# **KITITAS COUNTY**

### **MEMORANDUM**

SUBJECT: Forest Ridge Final Plat Resubmittal LPF-20-00005

PREPARED FOR FRPP PHASE I, LLC A PORTION OF SECTION 24, TOWNSHIP 20 NORTH, RANGE 15 EAST, W.M.		
KITTITAS COUNTY		WASHINGTON
DWN BY T.S.	DATE 01/2021	JOB NO. 18069
CHKD BY M.K.K./D.L.P.	SCALE N/A	SHEET 1 OF 6

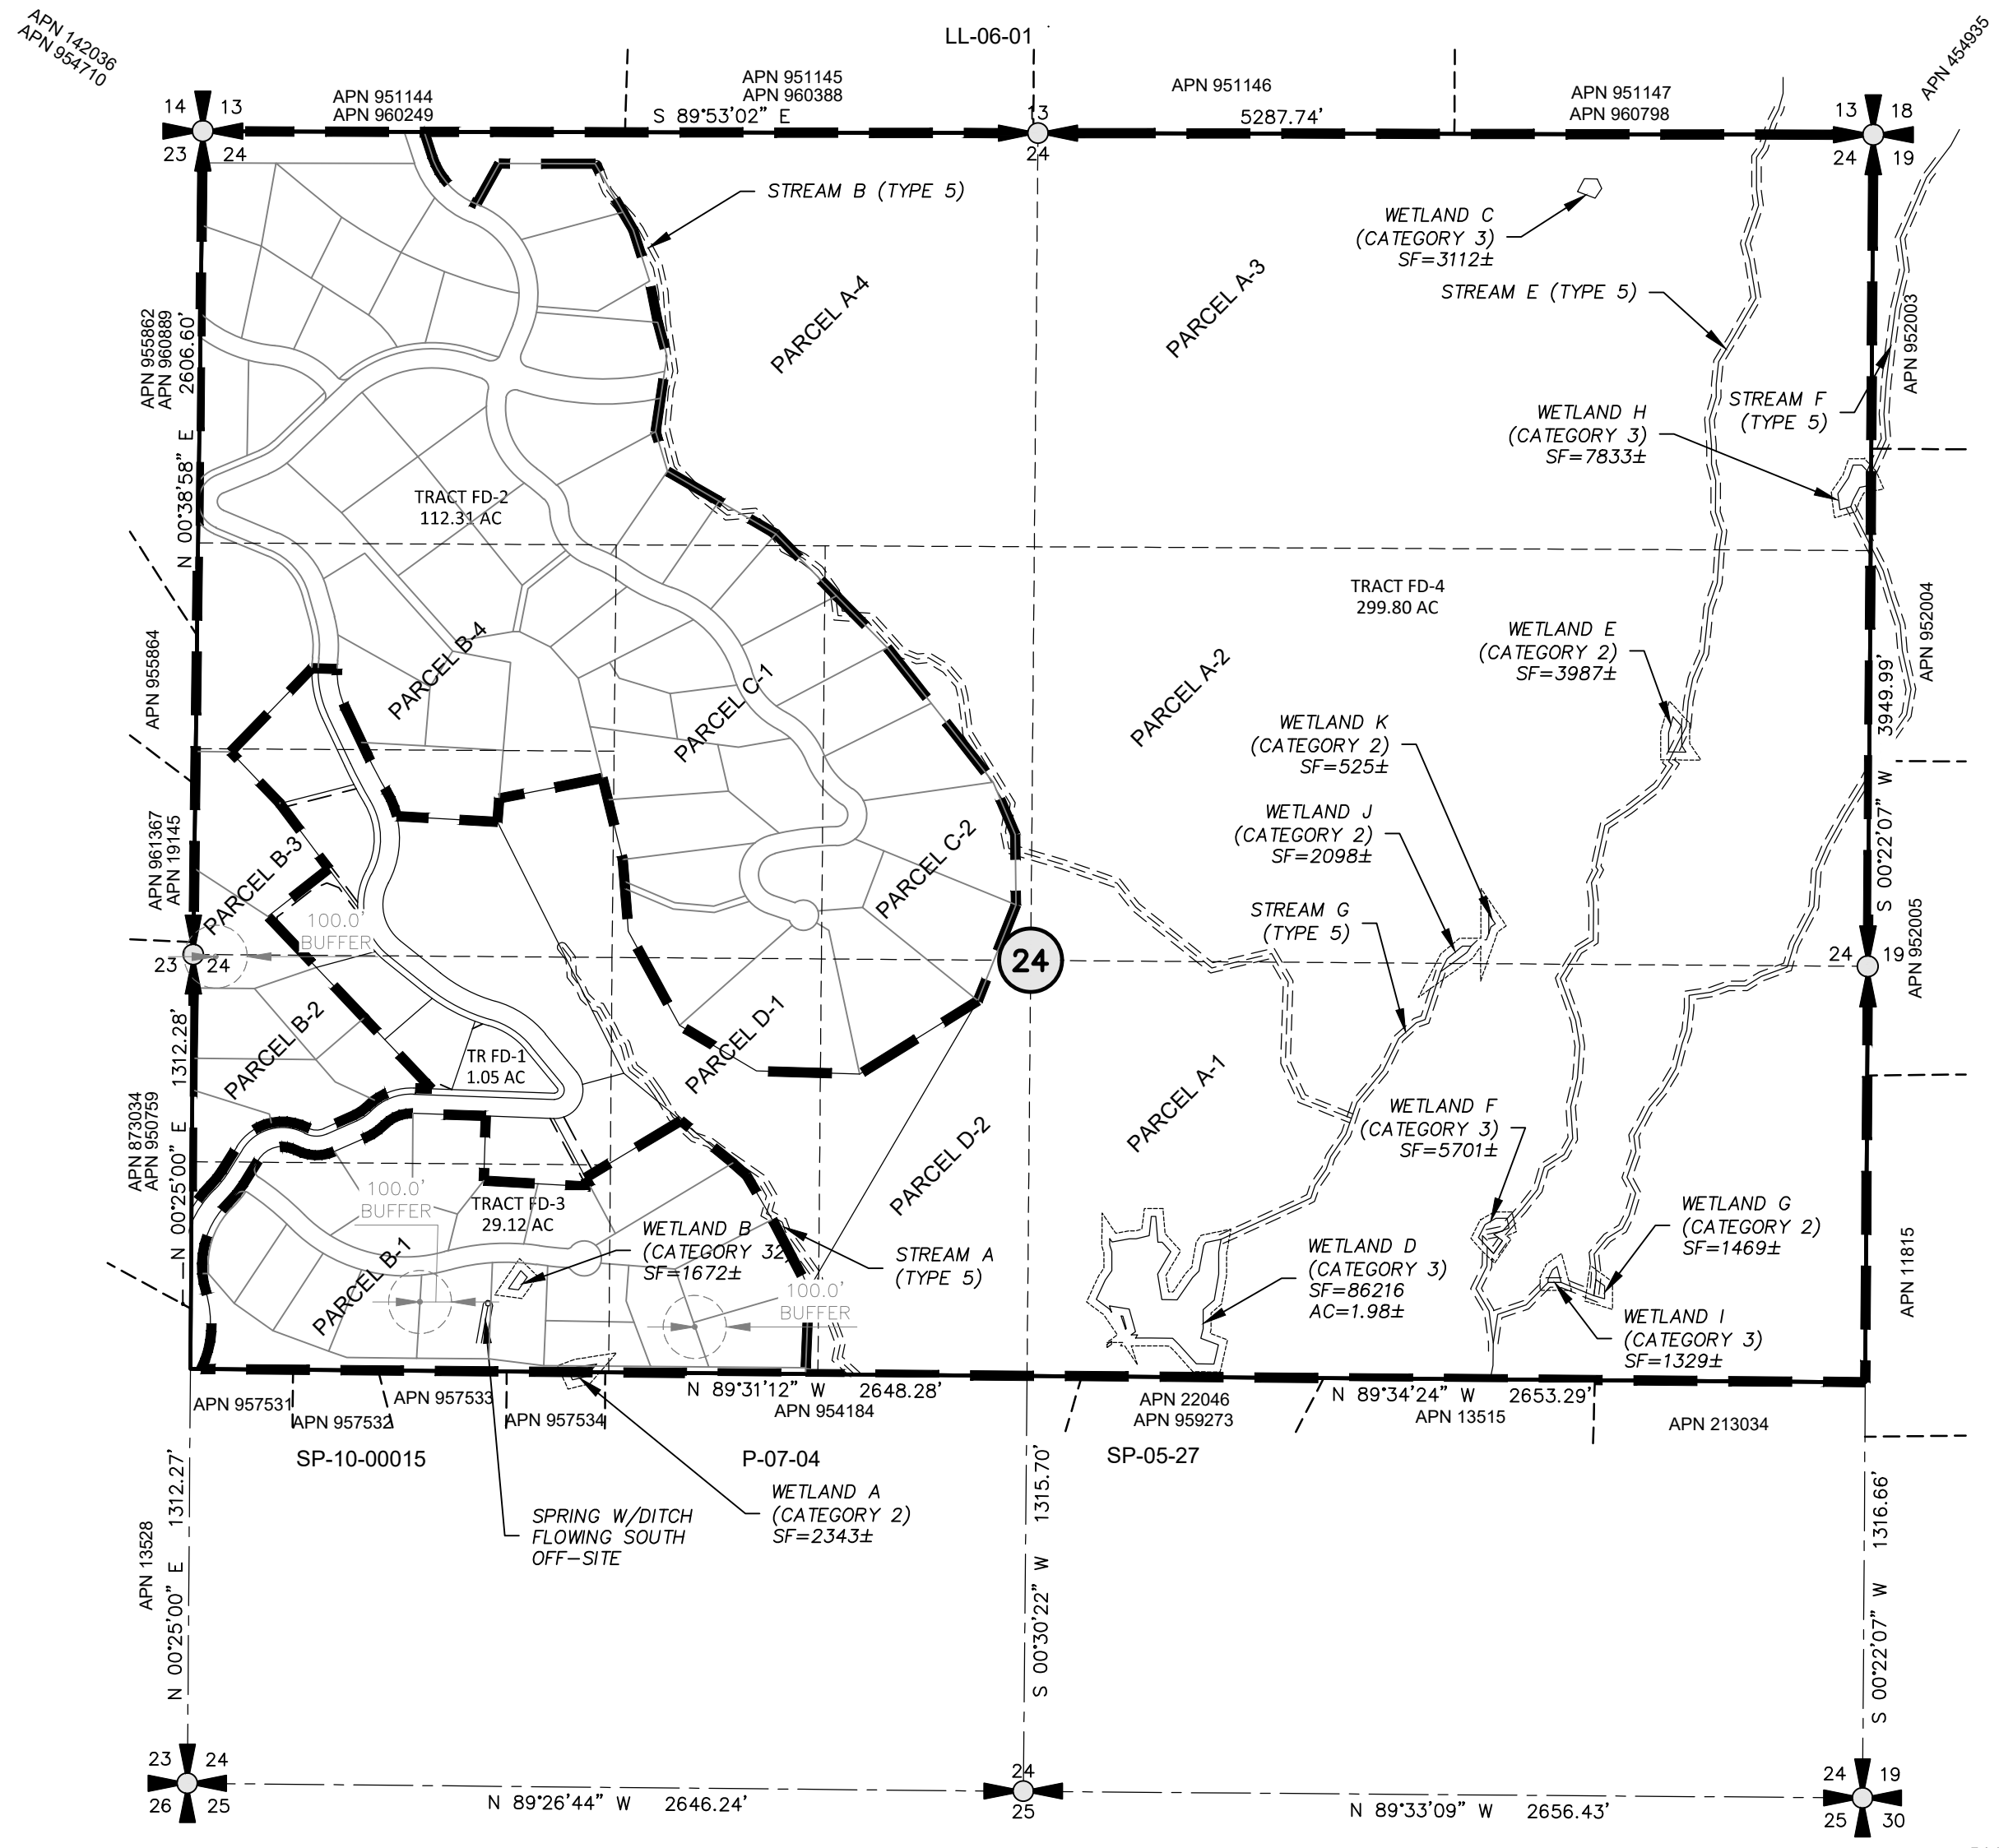
1. Survey Note 3, Sheet 1 shows a blank for the equipment used, and includes a few typos.
2. The N1/4 corner and the E1/4 corner do not have ties to determine the location.
3. Section corners are shown in the legend "as noted". Map contains no such notation.
4. The parcels identified as FD-2, FD-3 and FD-4 do not have any defined limits shown.
5. The historic parcels A-1 through D-2 can be confusing as they are not clearly identified as historic parcels. Including the recording number (AFN or Book and Page) would clarify this.
6. Set corners shall be shown on the face of the plat.
7. References to other pages (See Sheet X of X) are incorrect in the total page count, (all occurrences) as well as the reference page (n'most label, sheet 5)
8. There are multiple occurrences of labels being obscured by crossing linework.

FOREST RIDGE - PHASE I PERFORMANCE BASED CLUSTER PLAT PREPARED FOR FRPP PHASE I, LLC A PORTION OF SECTION 24, TOWNSHIP 20 NORTH, RANGE 15 EAST, W.M. KITITAS COUNTY WASHINGTON		
DWN BY T.S.	DATE 01/2021	JOB NO. 18069
CHKD BY M.K.K./D.L.P.	SCALE 1" = 100'	SHEET 3 OF 6

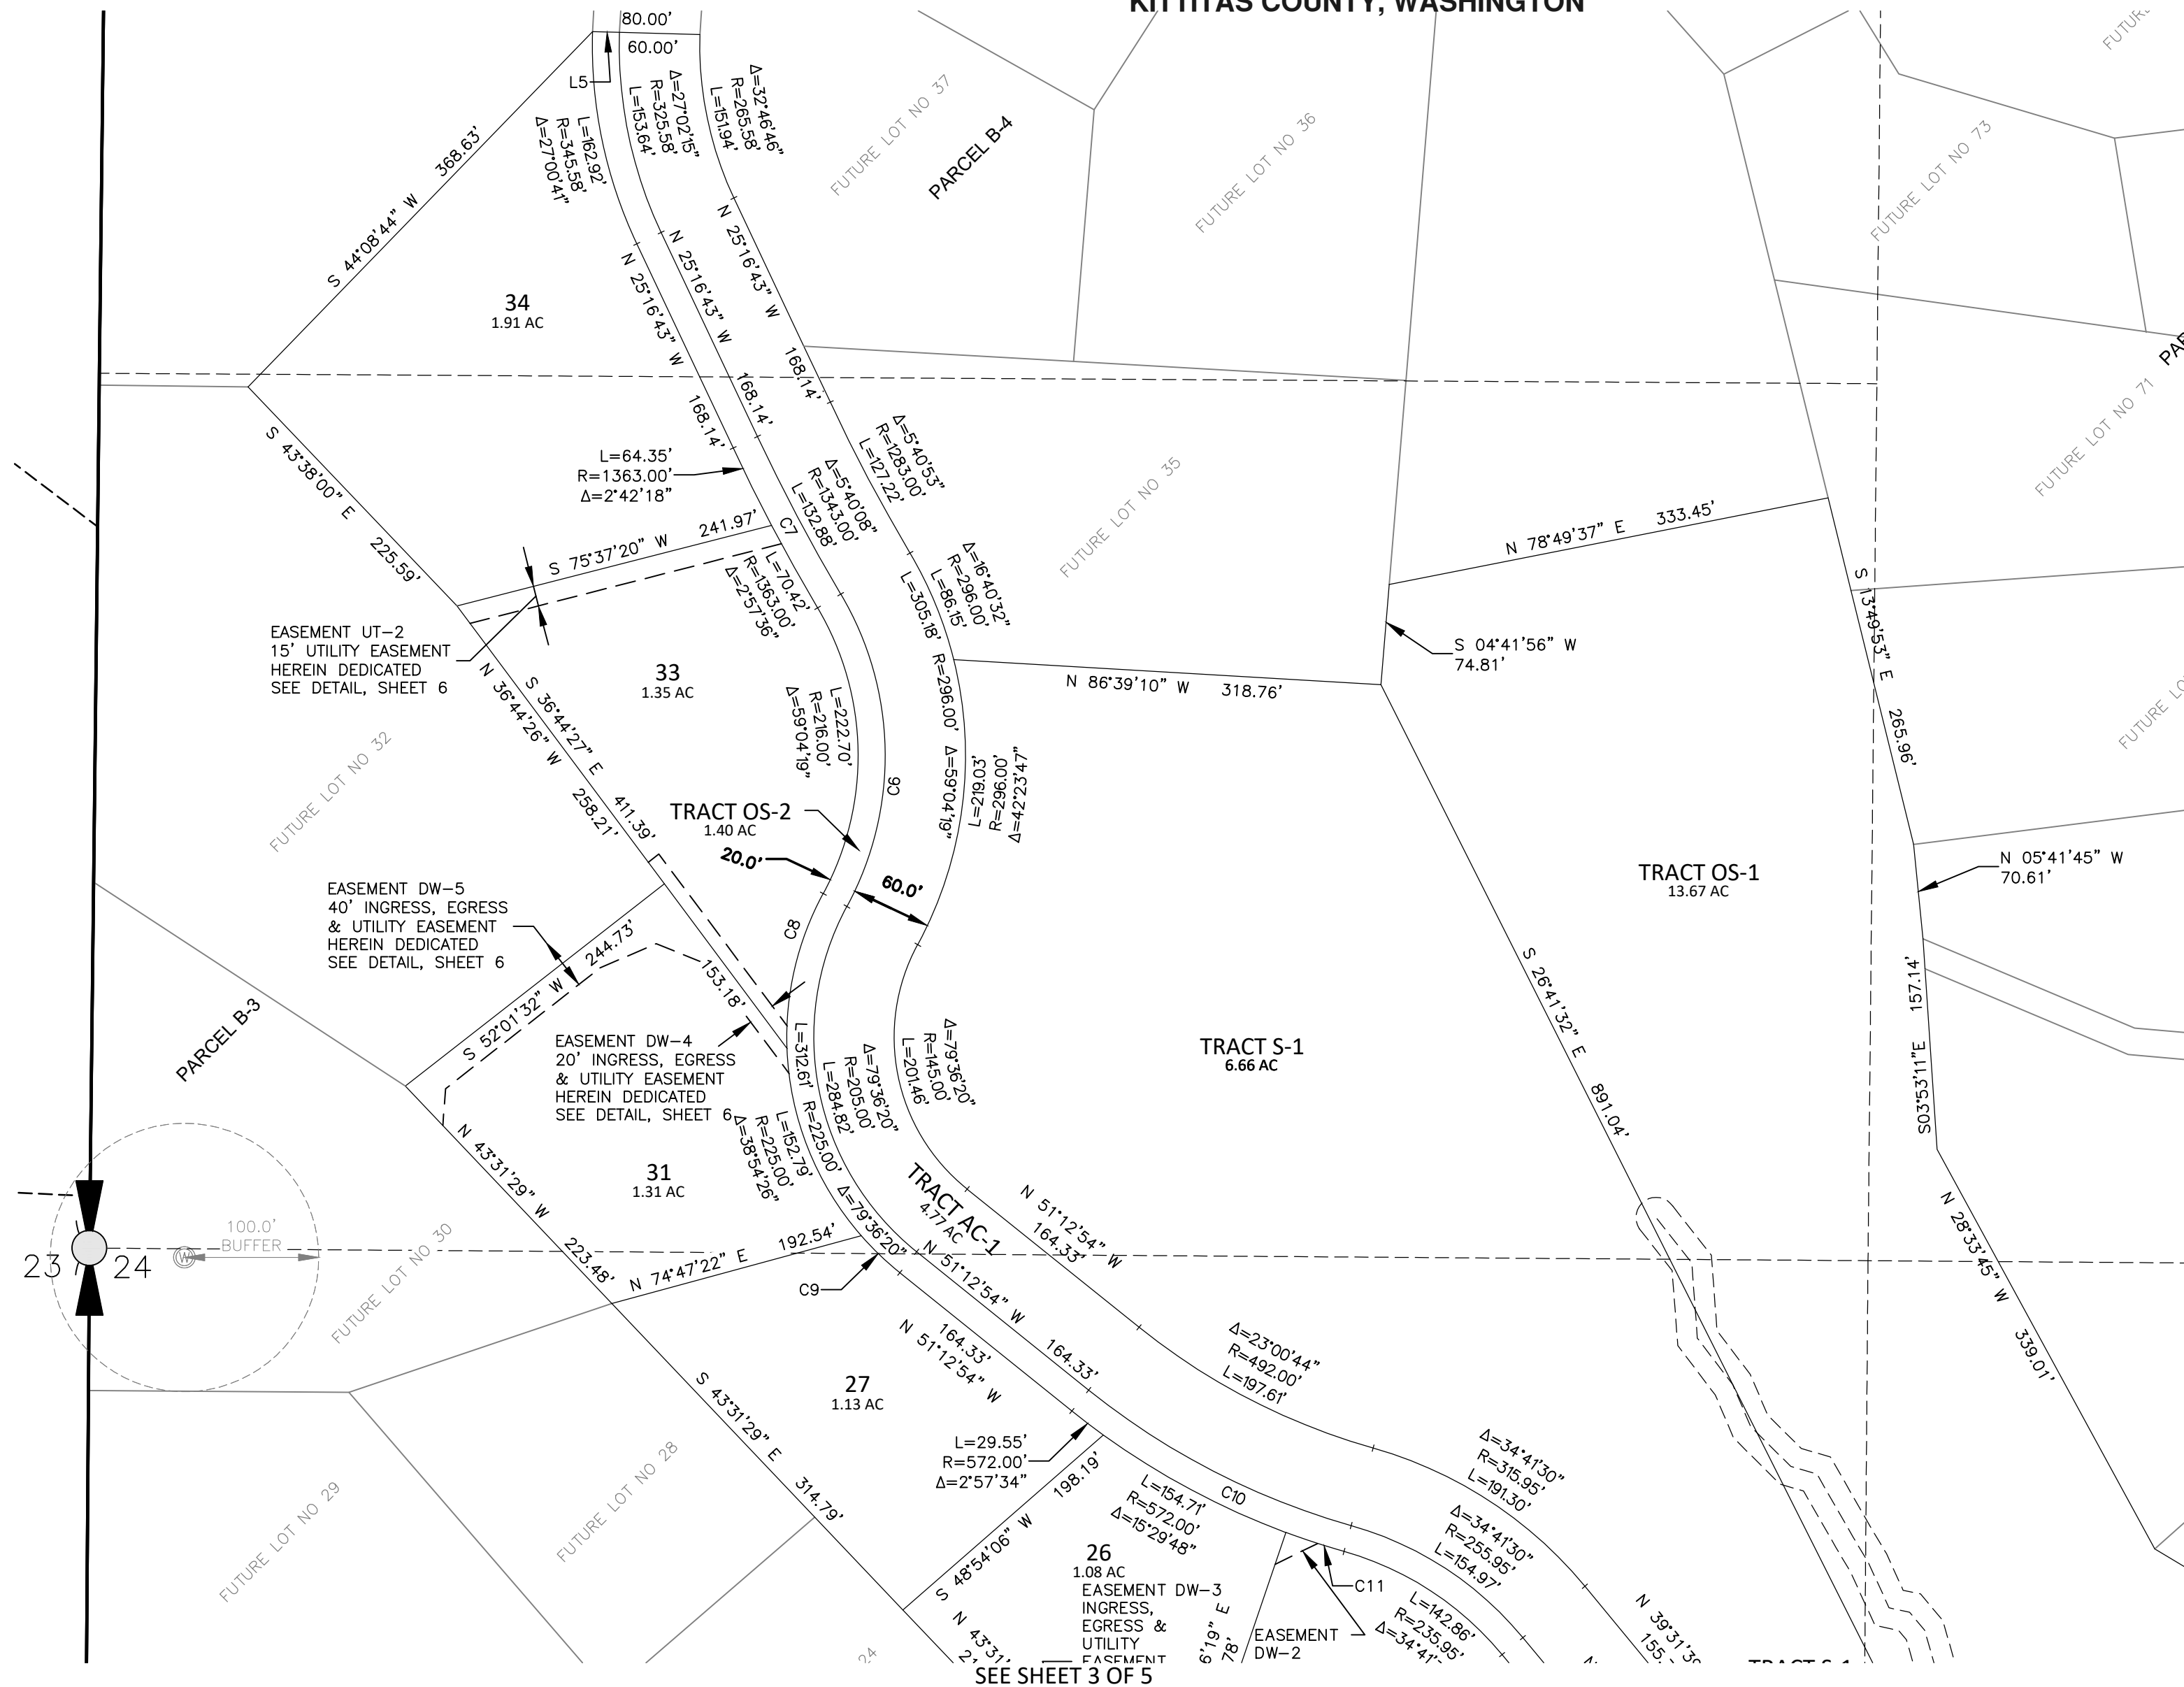
12. The East Boundary of AC-1, adjacent to Future Lot 37 does not match the closure report.
13. The North Line of the Easement DW-5 appears to have missing linework. It is also discrepant between page 6 and page 4.
